From: Amanda Scholes on behalf of Planning.Responses
Sent: 07 April 2021 10:08
To: Planning Scanning
Subject: FW: Y/155/20/DOC and Y/3/21/DOC - Condition 10 and 9

From: Laura Gibbons <Laura.Gibbons@arun.gov.uk>
Sent: 07 April 2021 09:46
To: Simon Davis <Simon.Davis@arun.gov.uk>
Cc: Planning.Responses <Planning.Responses@arun.gov.uk>
Subject: RE: Y/155/20/DOC and Y/3/21/DOC - Condition 10 and 9

Thanks for sending this over and sorry that it has taken some time to get comments back to you. My comments are shown below, in summary there are a lot of points outstanding with a large degree of information still not supplied. I've got a meeting with the applicant's consultant later today where I will run through my comments with them.

P:19-326 - Bilsham Road, Yapton RMT Technical Drawings 000 Series 19-326-010 Preliminary Engineering Layout Sheet 2 of 2.dwg

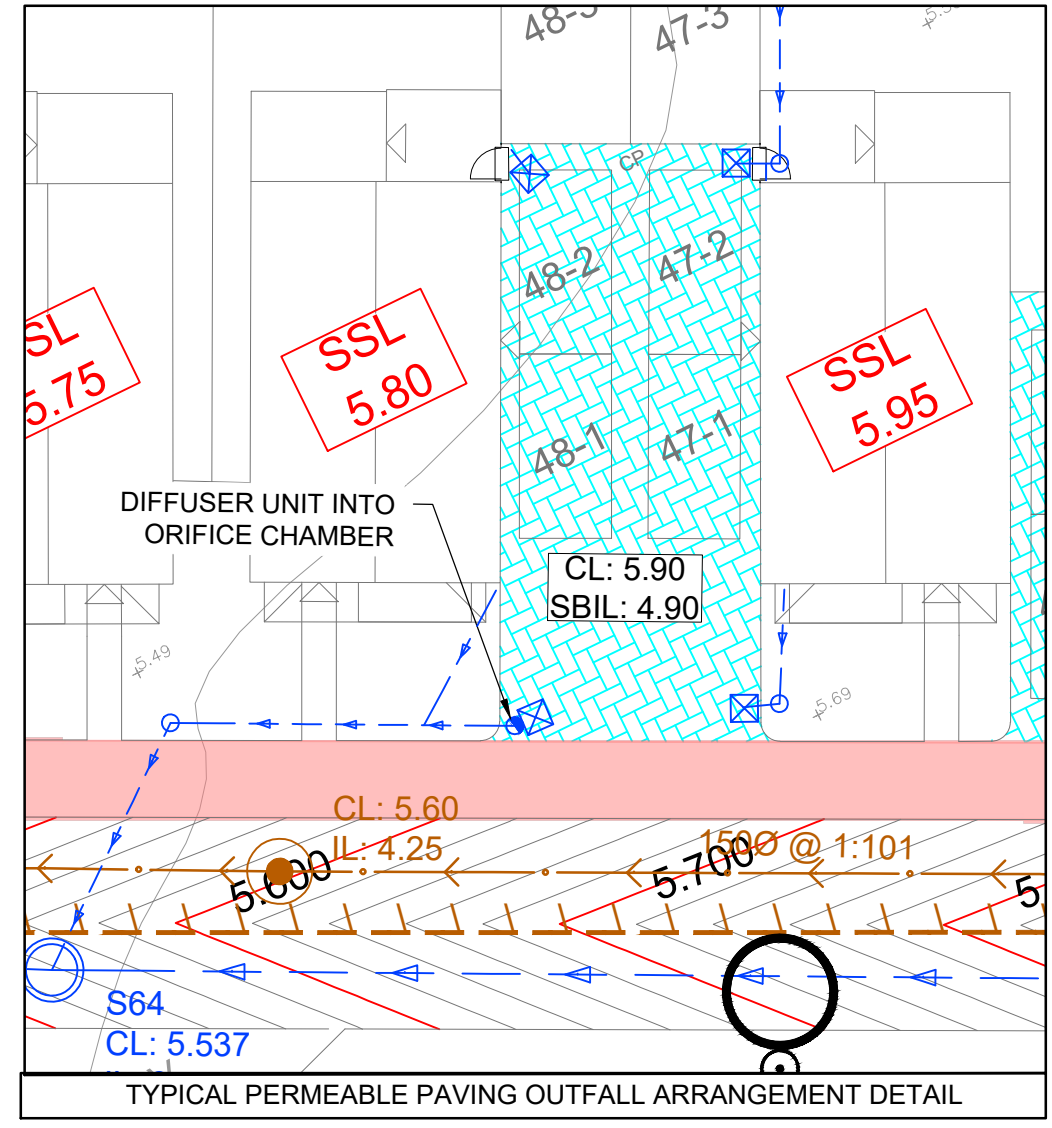
2. Groundwater monitoring results must be provided and should be overlaid on detailed drainage layout drawings. *The results of groundwater monitoring are provided in Drawings 19-326/009 and 19-326/010 in Appendix B. Okay, thank you.*

3. Detailed layout plans must be provided.
 - a. All pipes must be labelled with diameters and falls. *The diameters of the proposed pipes were included in the submitted drainage strategy drawings. The falls have been added to show the gradient of the pipes, and are shown in Appendix B. Okay, to be reviewed (see below for details of why this hasn't been reviewed yet).*

- b. Manhole invert and cover levels must be provided. *The invert and of cover levels of the proposed manholes are shown in Appendix B. Okay, to be reviewed (see below for details of why this hasn't been reviewed yet).*

- g. The invert level of the proposed connections to the culvert and watercourse must be provided, along with the invert level of these existing features at the proposed points of connection. Upstream and downstream bed levels of watercourses must also be provided on plans. *The invert levels of the proposed connections are provided within the drainage calculations in Appendix C. The invert level of the connection to the culvert has been interpolated using drainage survey data, and the invert level of the connection to the watercourse has been identified from the topographical survey included on the drawings in Appendix B. The invert levels must be provided on layout drawings. The*

achievability of the ditch outlet level of 4.41 is highly questionable with ditch bed levels in this area of at least 4.51, and a minimum of 150mm required between ditch bed and outlet invert level.

10. **300mm freeboard must be provided on all basins.** *At least 300mm freeboard is provided for two of the basins. Where less than 300mm is provided on the remaining basins, exceedance flows would be directed away from the new homes and as such would not impact on the proposed development. A minimum of 300mm freeboard is required on all basins and is non-negotiable.*
